ENG-PUDSP21006-R2-PUDSP.pdf Markup Summary

SHEET 13 OF 27

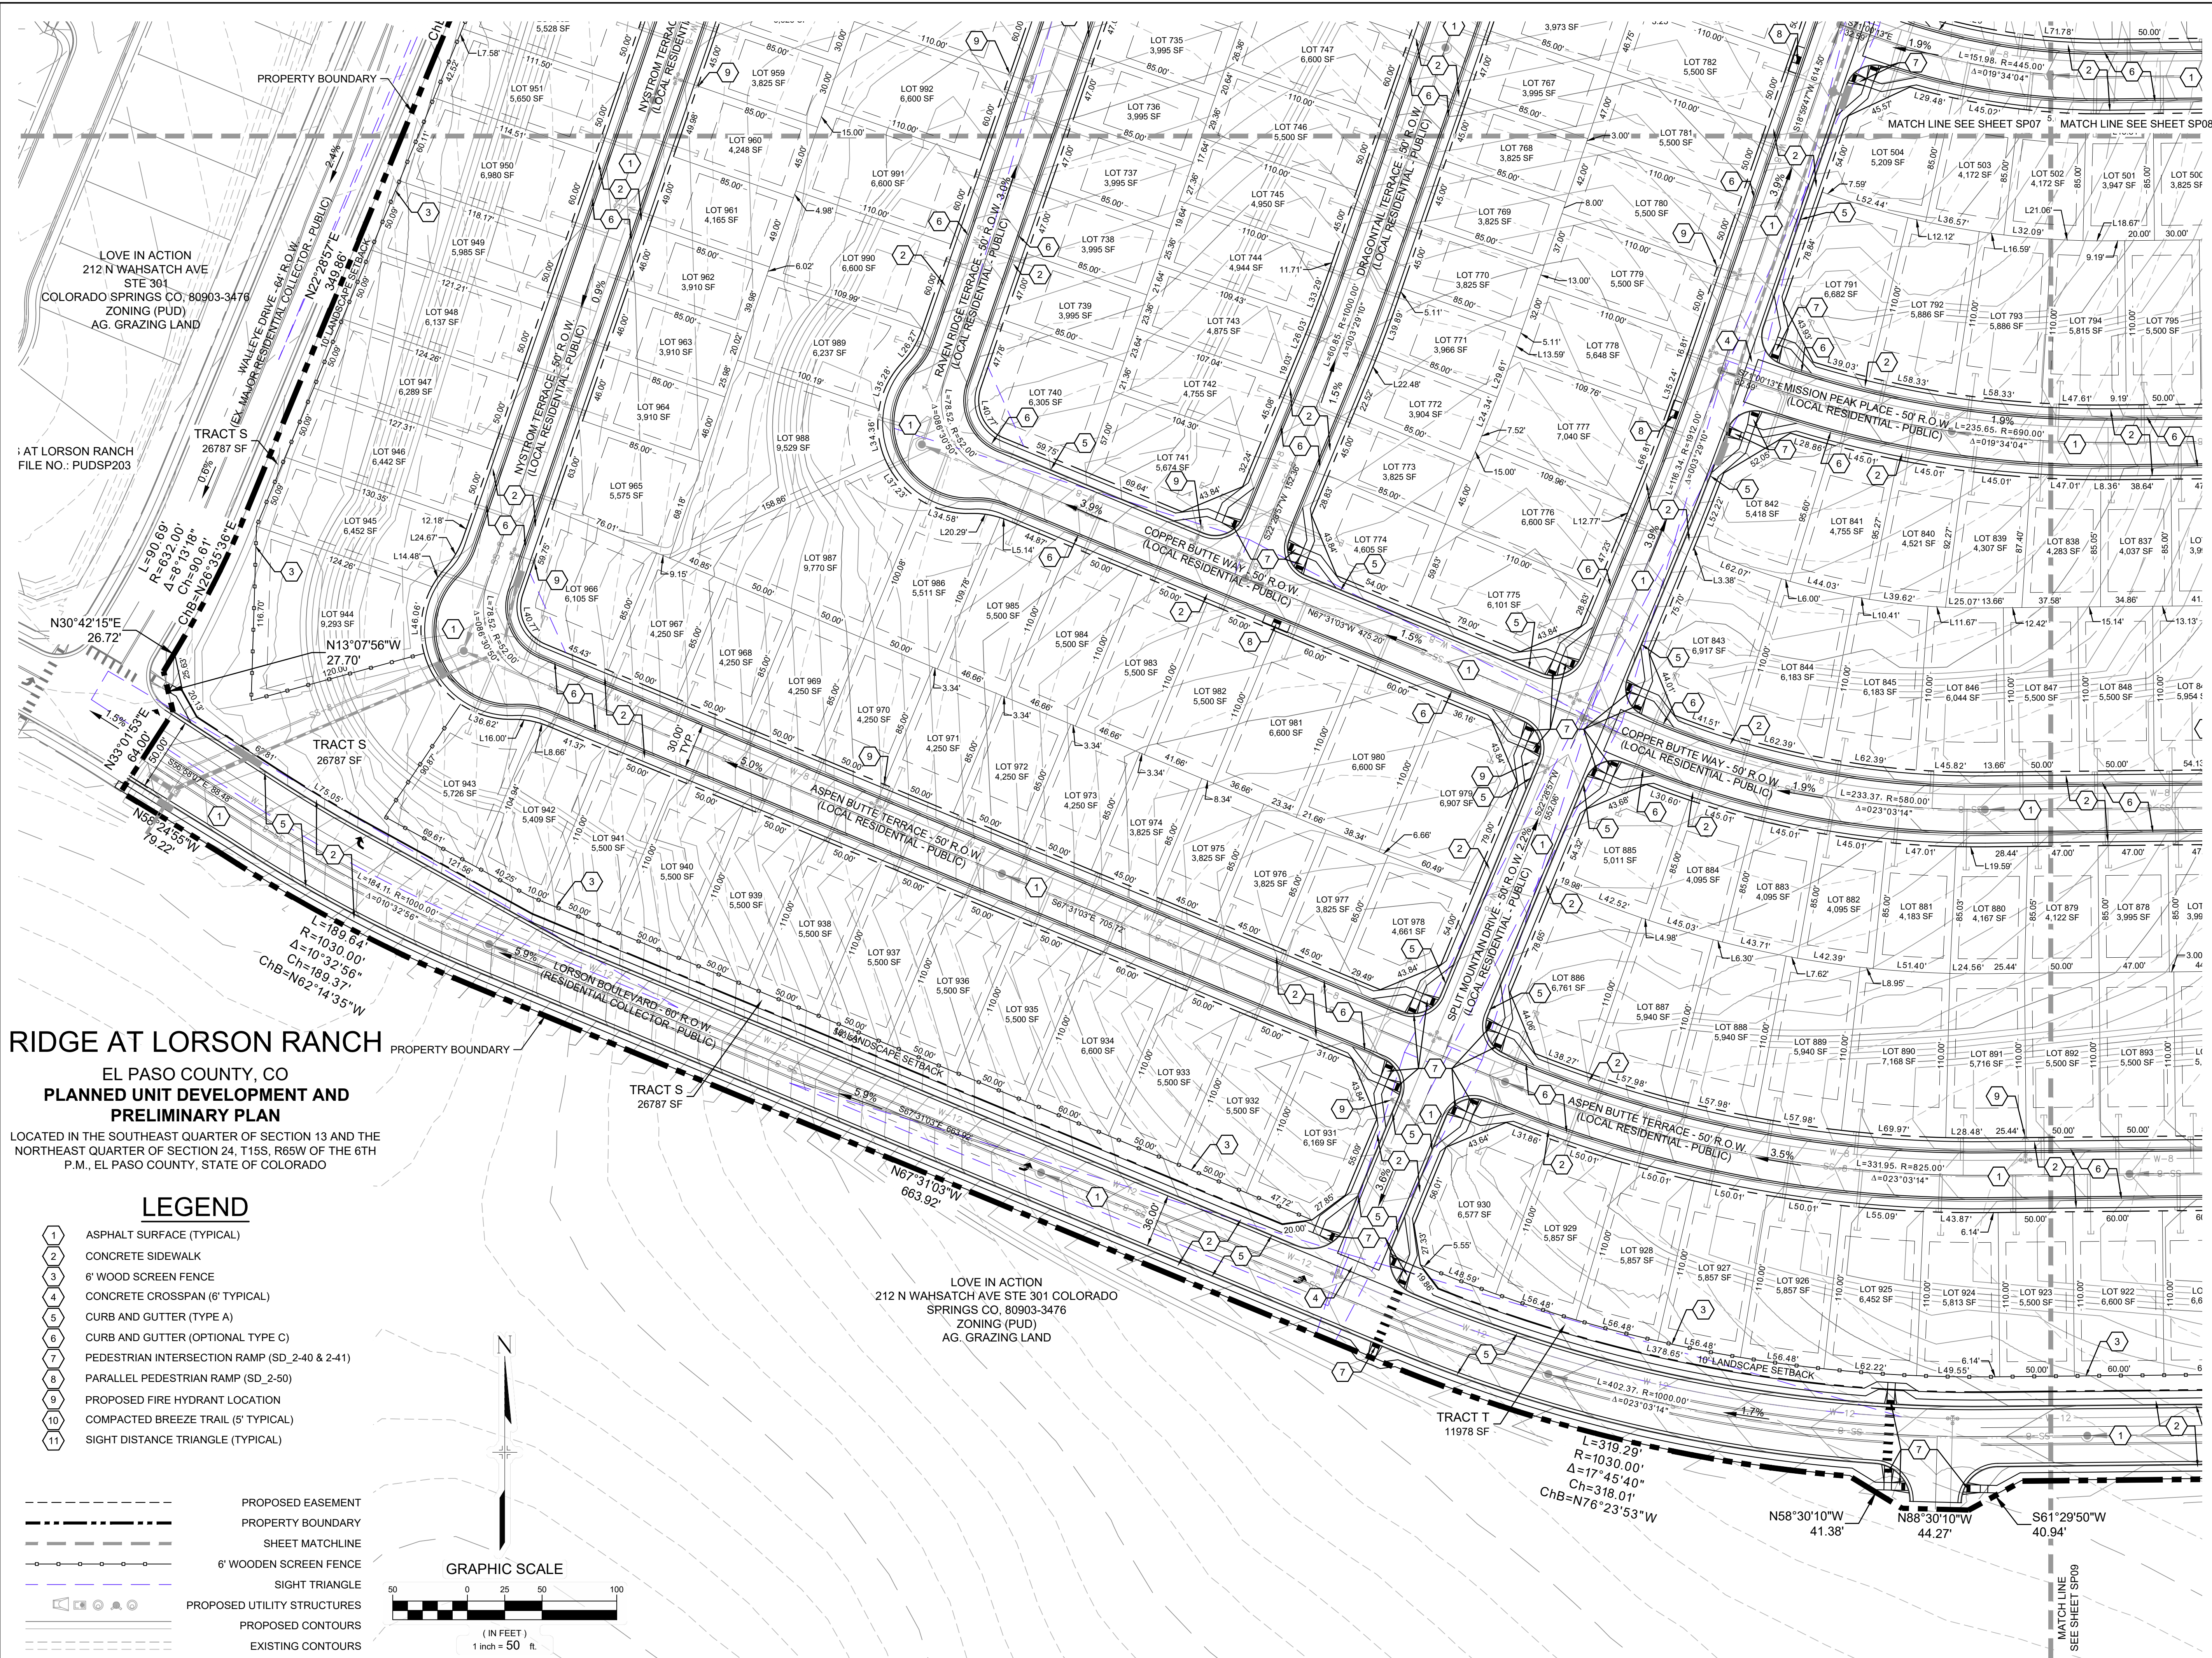
Show pond and downstream conveyance

SHEET 17 OF 27

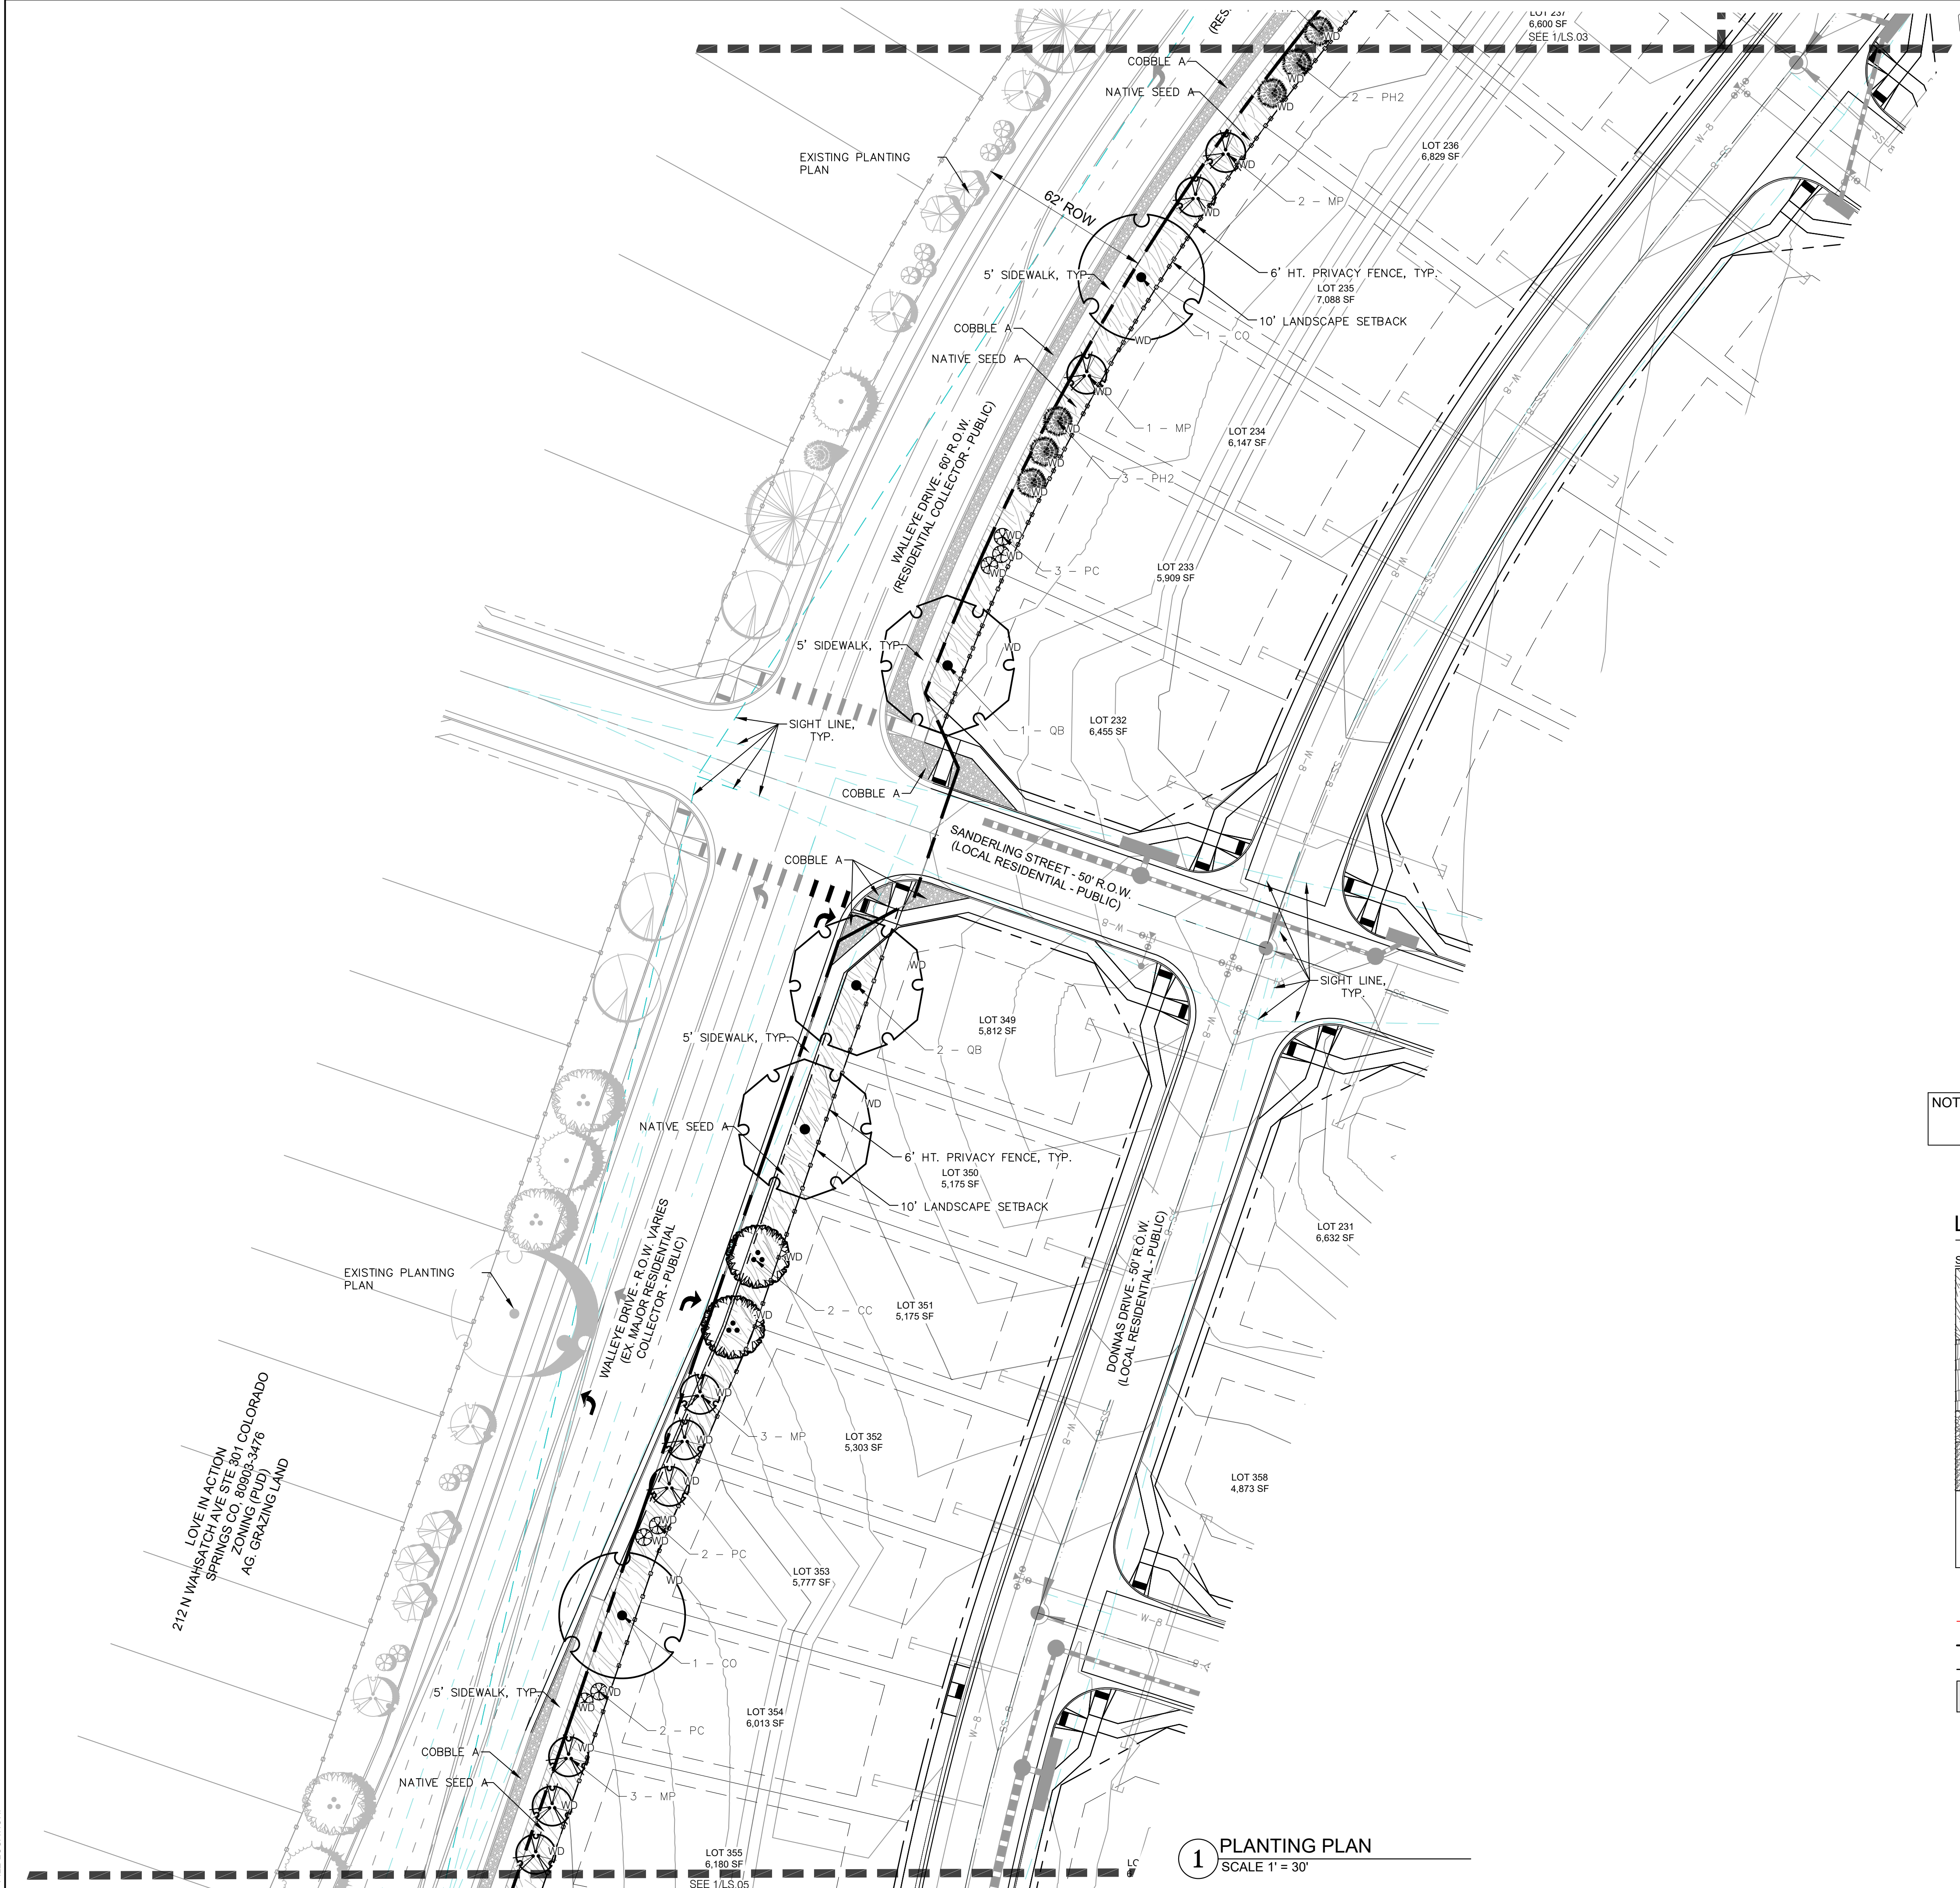
Planning defers to Jeff Rice to determine if the sight triangles are based on ECM- they look different than I see typically.

SHEET 11 OF 27

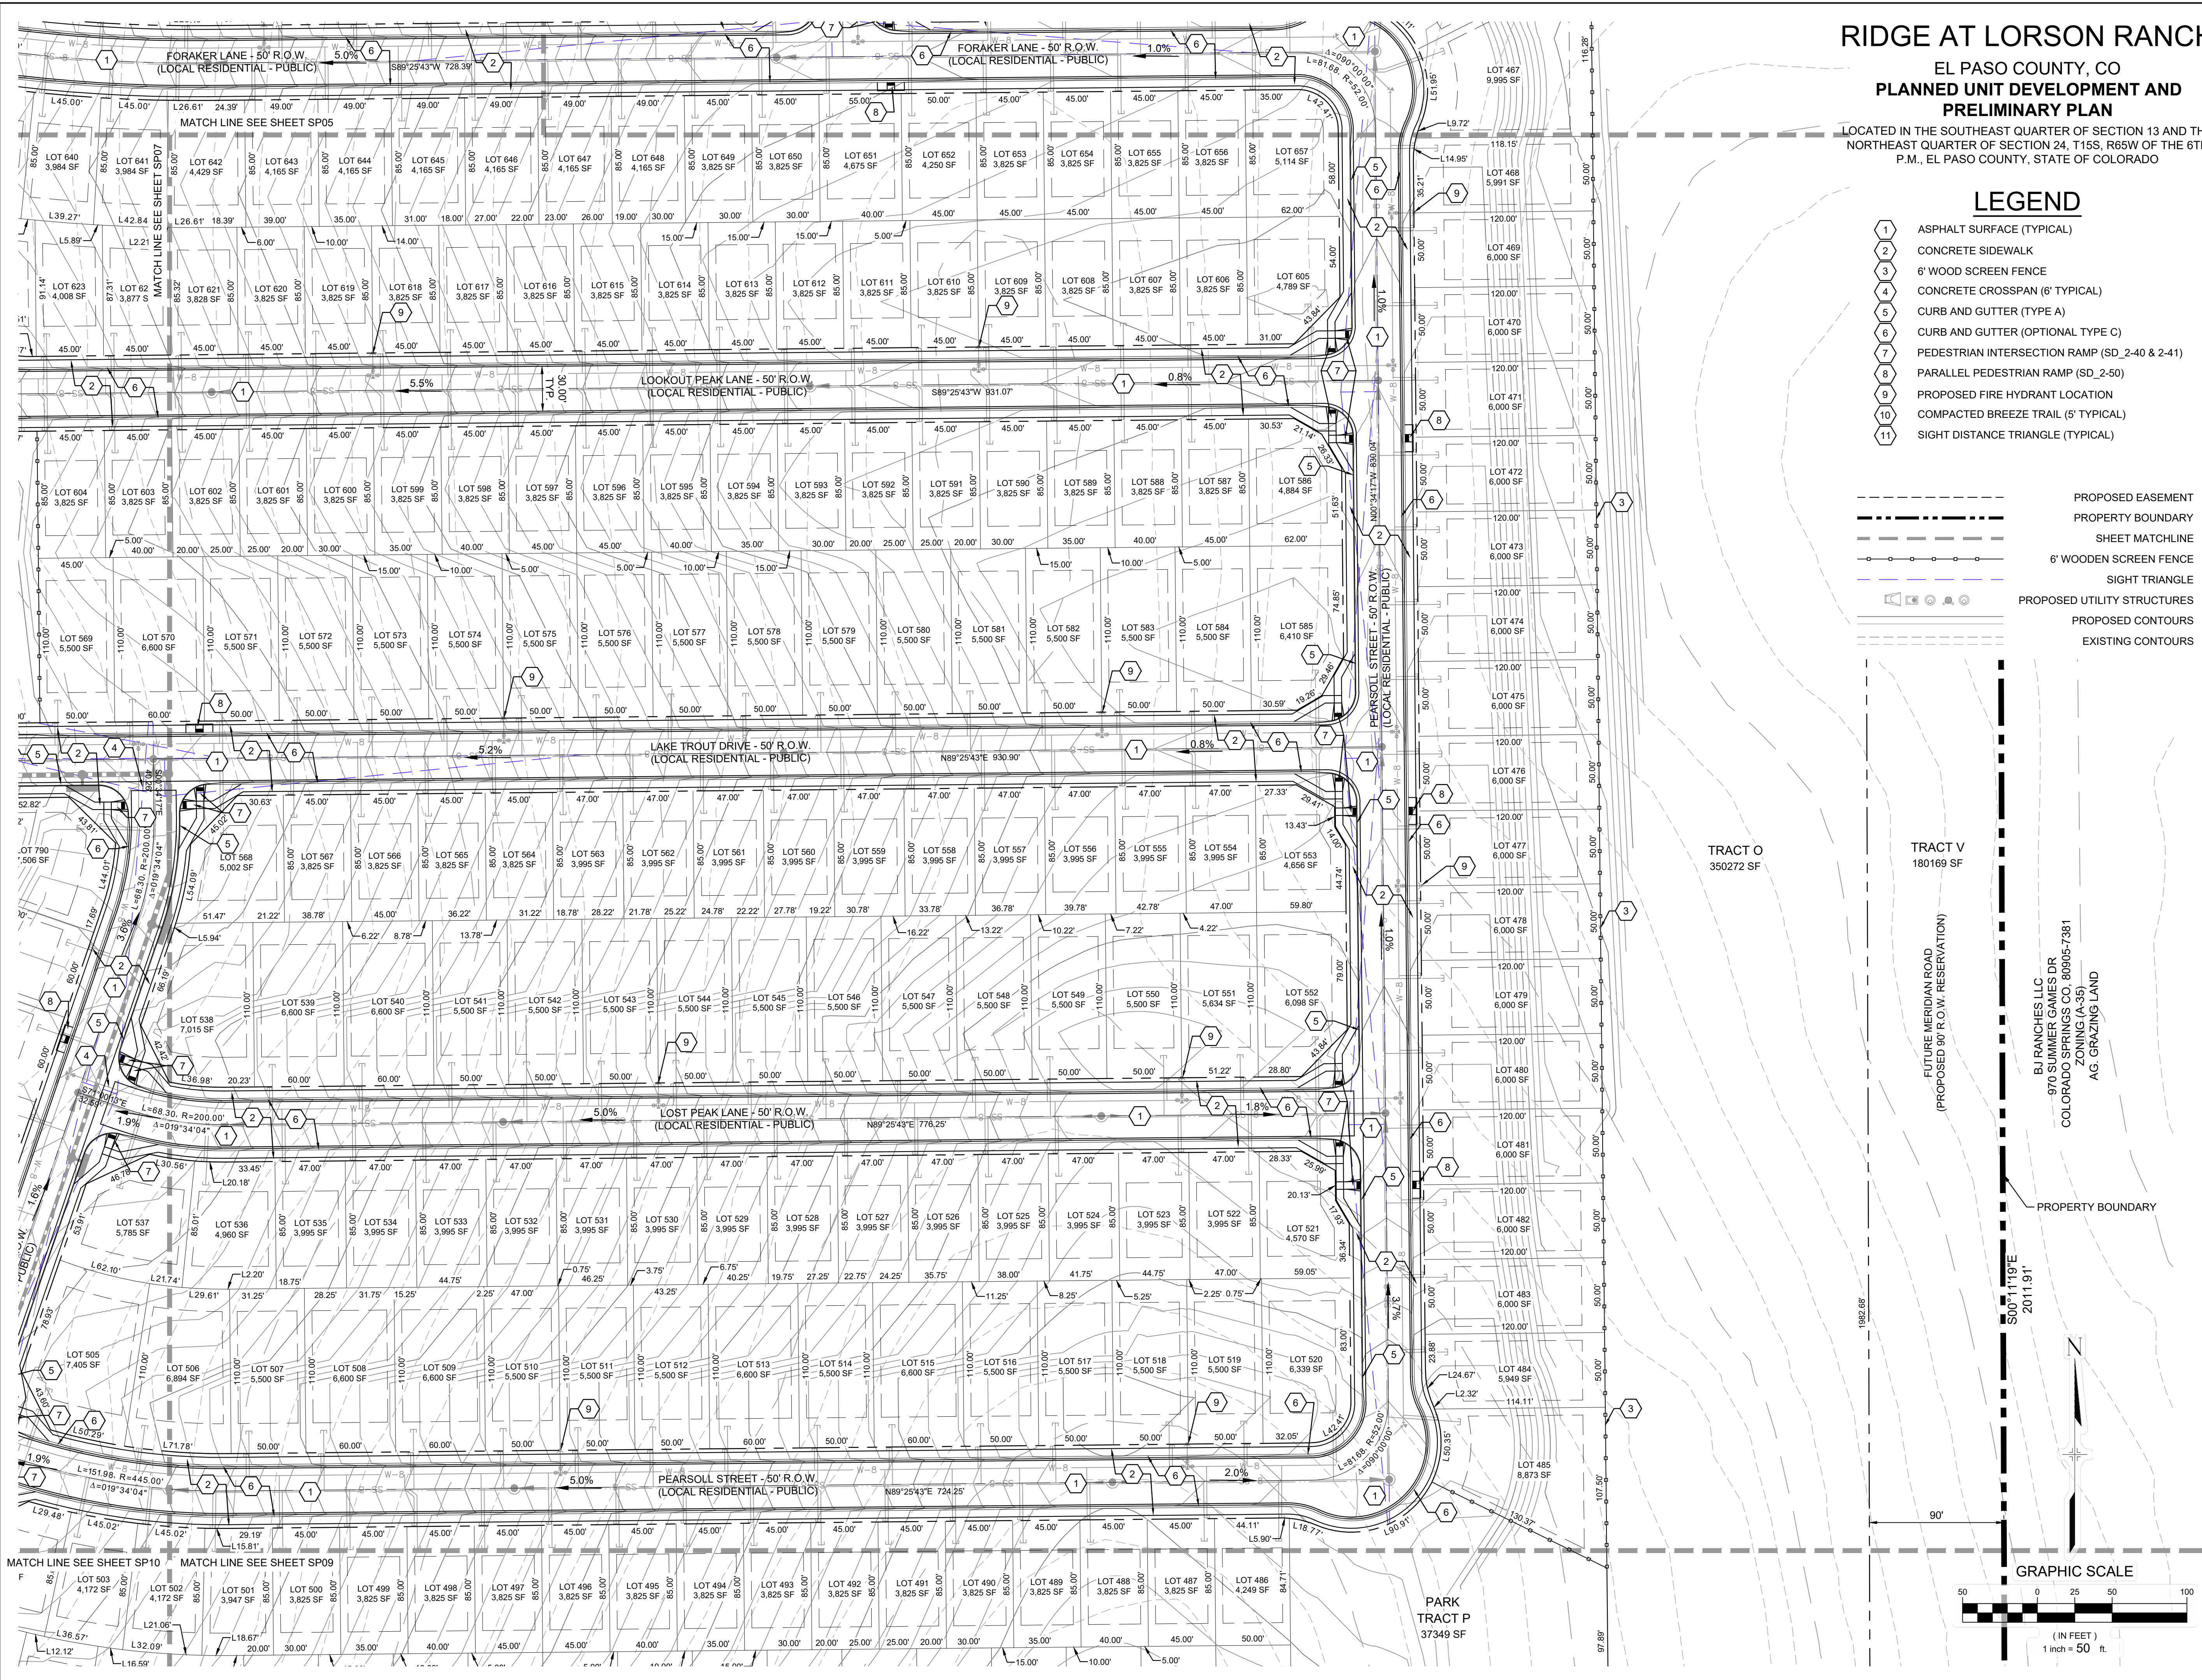
Adjust lots and fencing out of the sight distance easement
